**PAVEMENT DESIGN REPORT  
LATIGO TRAILS FILING NO. 9  
EL PASO COUNTY, COLORADO**

June 13, 2024

Entech Job No. 231802

FIG. 1

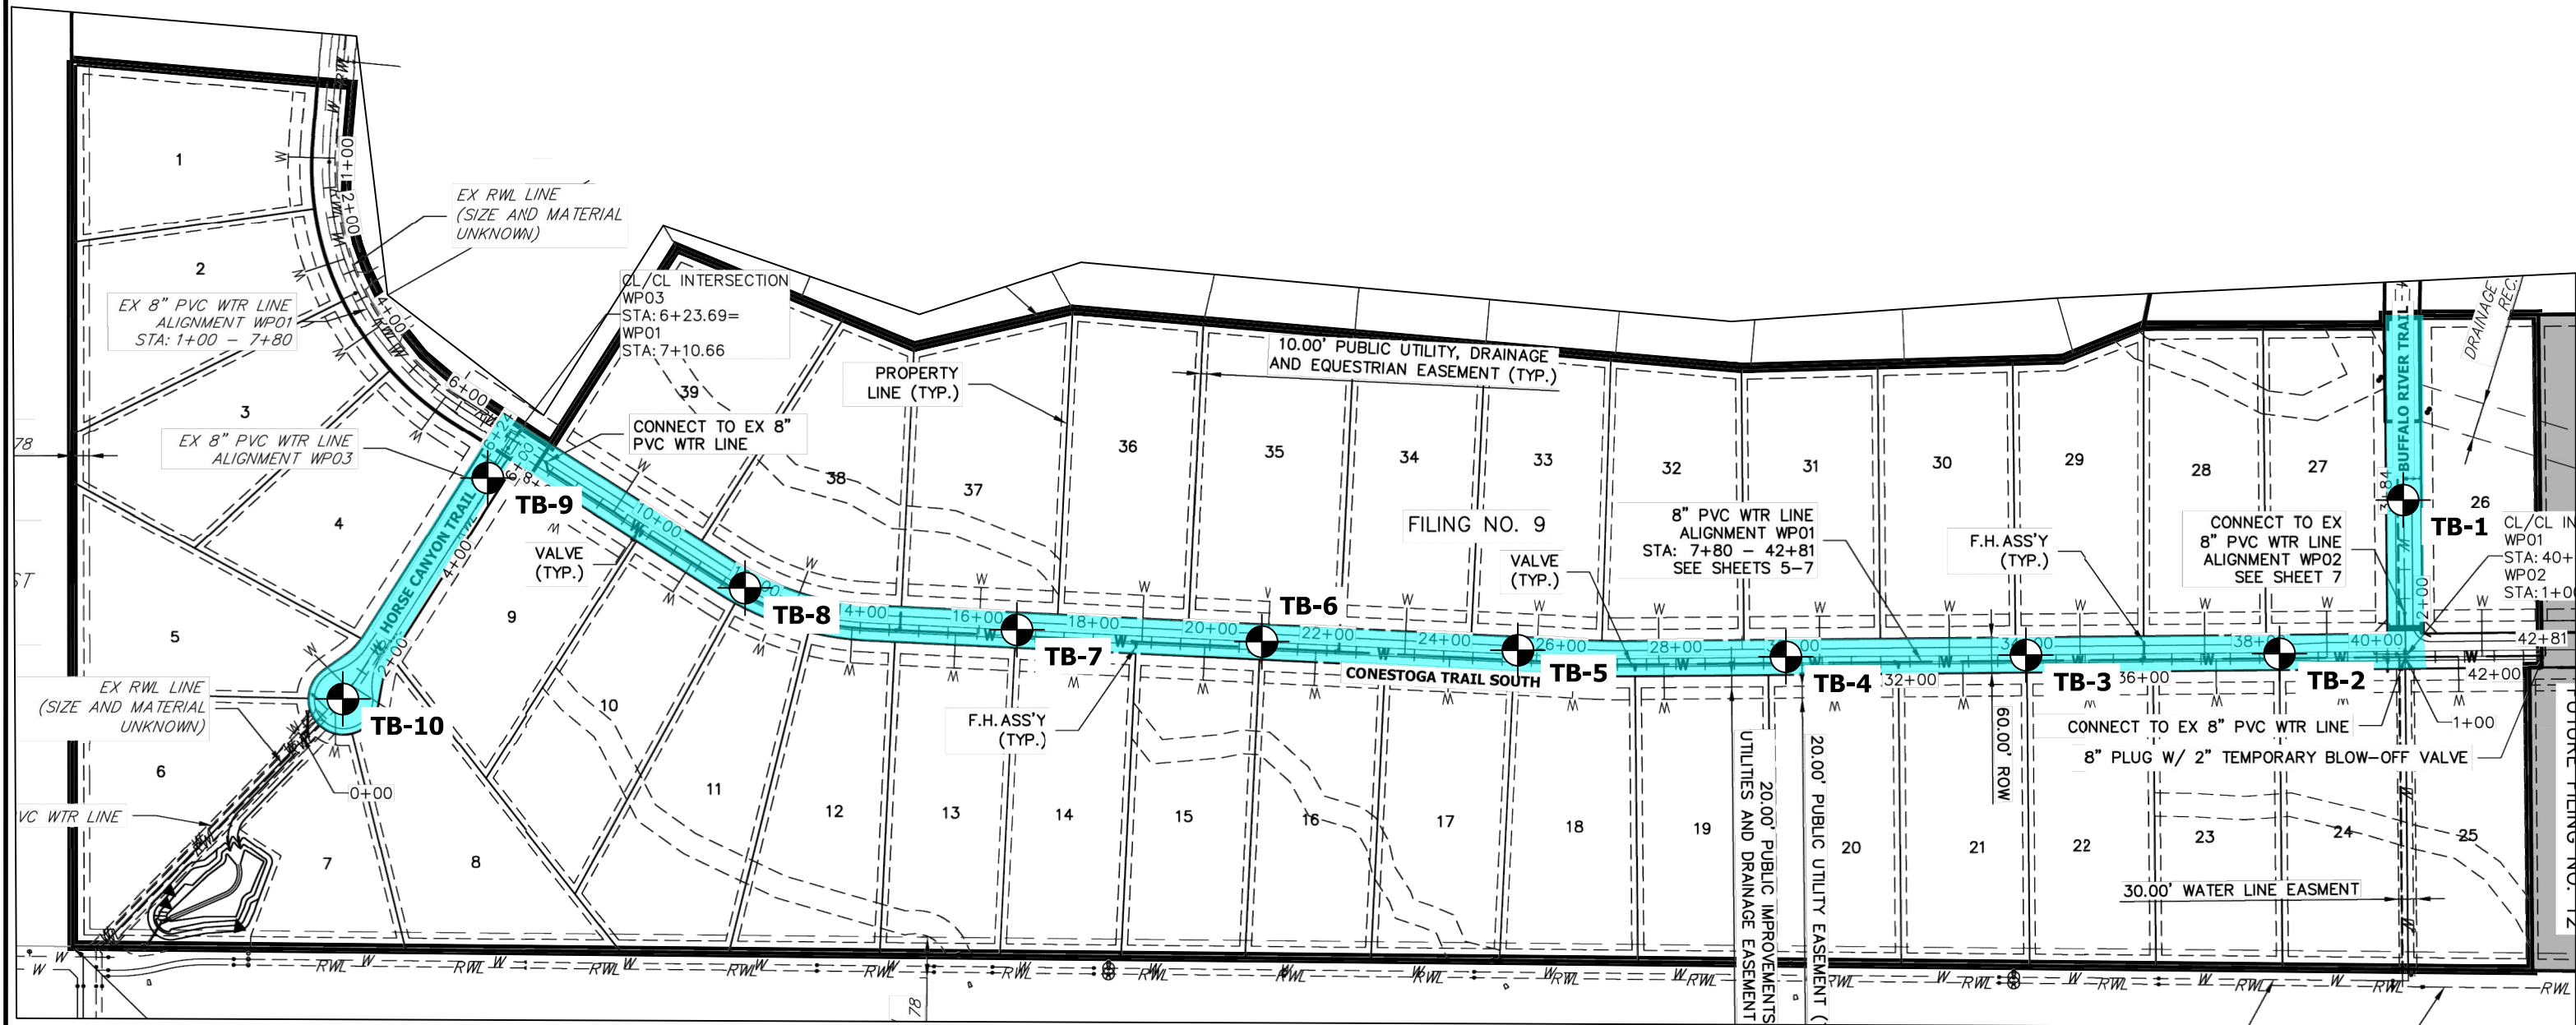
Please add a hatching or color indicating the areas to receive the proposed pavement section

**TABLE B-1  
SUMMARY OF LABORATORY TEST RESULTS**

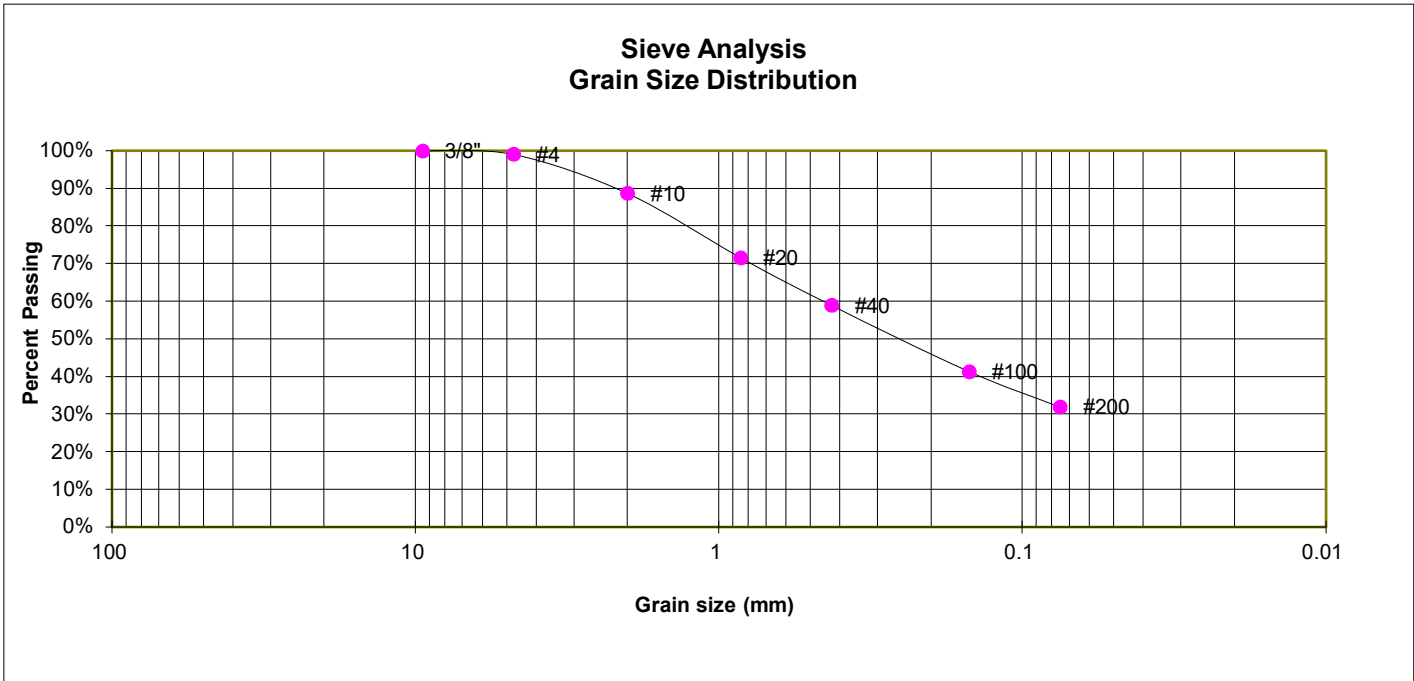
Please include moisture content for samples
